Our Ref: AL/89/11/

Single storey rear extension & bedroom at first floor in proposed roof conversion (re-submission following AL/72/11/)
Bramber Hook Lane Aldingbourne

I regret that I am unable to accept your documents as a formal application until the following matters have been resolved :-

SITE PLAN - SCALE 1:500

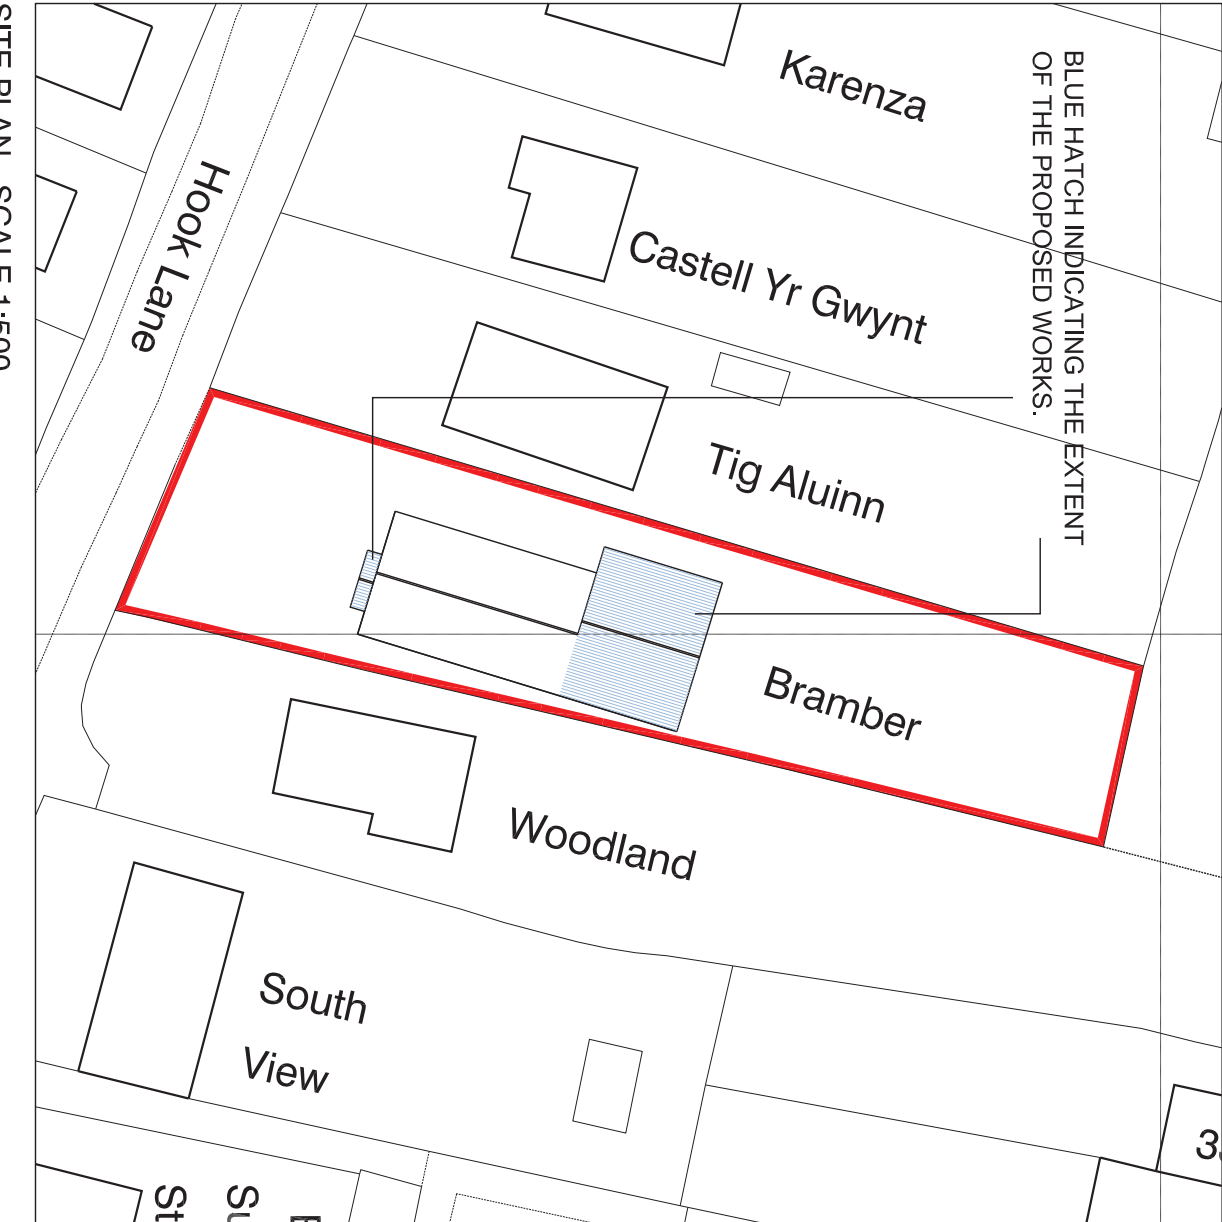
I require 1 electronic or 3 paper copies of a revised block/site plan to show the proposed works clearly highlighted, in accordance with the guidance notes available on our website detailed below (click on National List).
